Our ref: HA/2021/123836/03-L01
Your ref: WA/32/21/PL
Date: 06 May 2022

**ADDITIONAL INFORMATION - CONSTRUCTION OF 30 NO. DWELLINGS
TOGETHER WITH ASSOCIATED ACCESS, PARKING, PUBLIC OPEN SPACE &
LANDSCAPING LAND AT WEST WALBERTON LANE, WALBERTON, BN18 0QF.**

Environment Agency Position

We **maintain our objection** to the proposed development as submitted.

PROJECT
Proposed Development, West Walberton
Lane/Eastergate Lane, Walberton
CLIENT
Macra
STATUS
FOR PLANNING
DRAWING
Proposed Site Sections

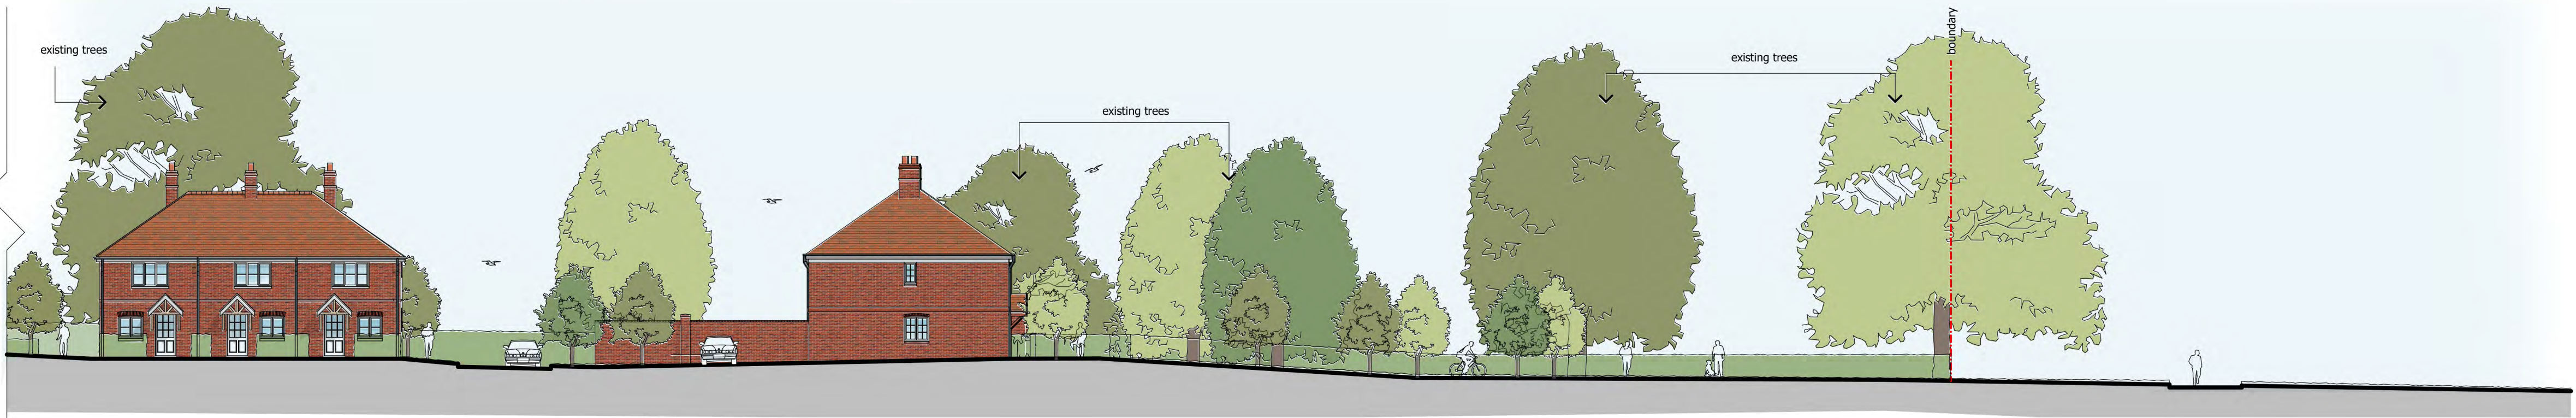
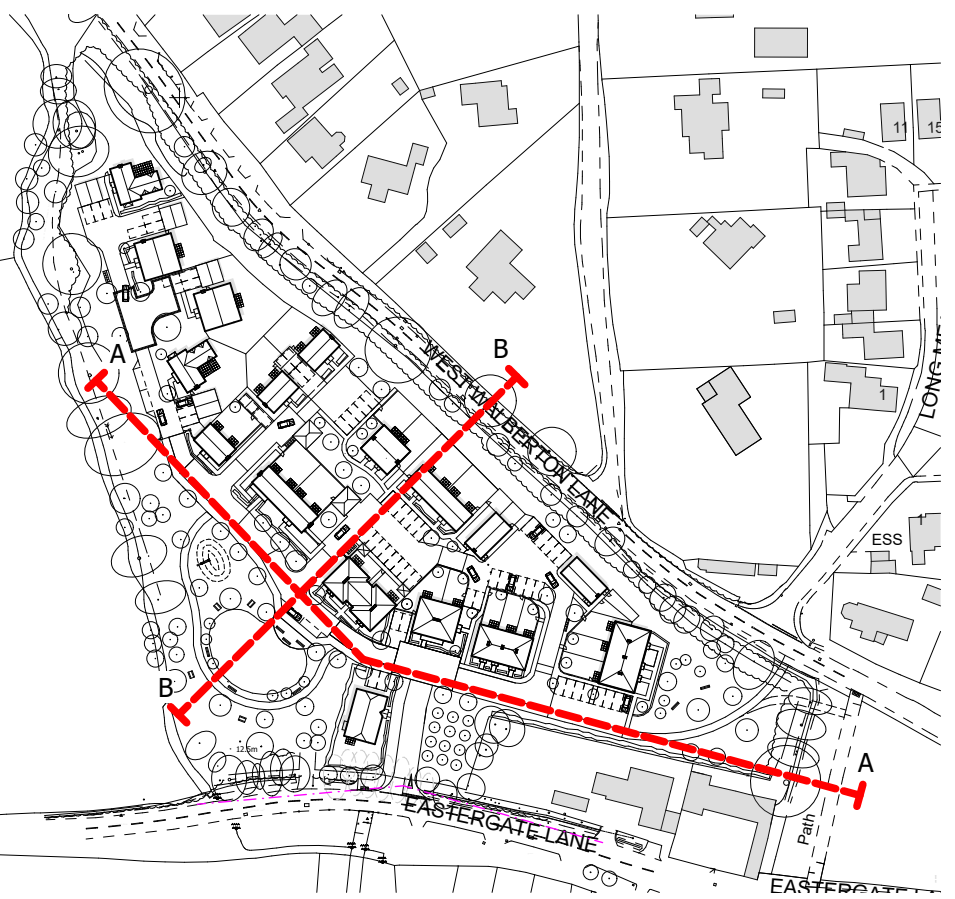
We would like to know how the level of the ecology pond within the compensation area would be managed. We note that the area will be lined with clay meaning the compensation area will act like a water-tight basin with a single outlet into the Barnham Rife.
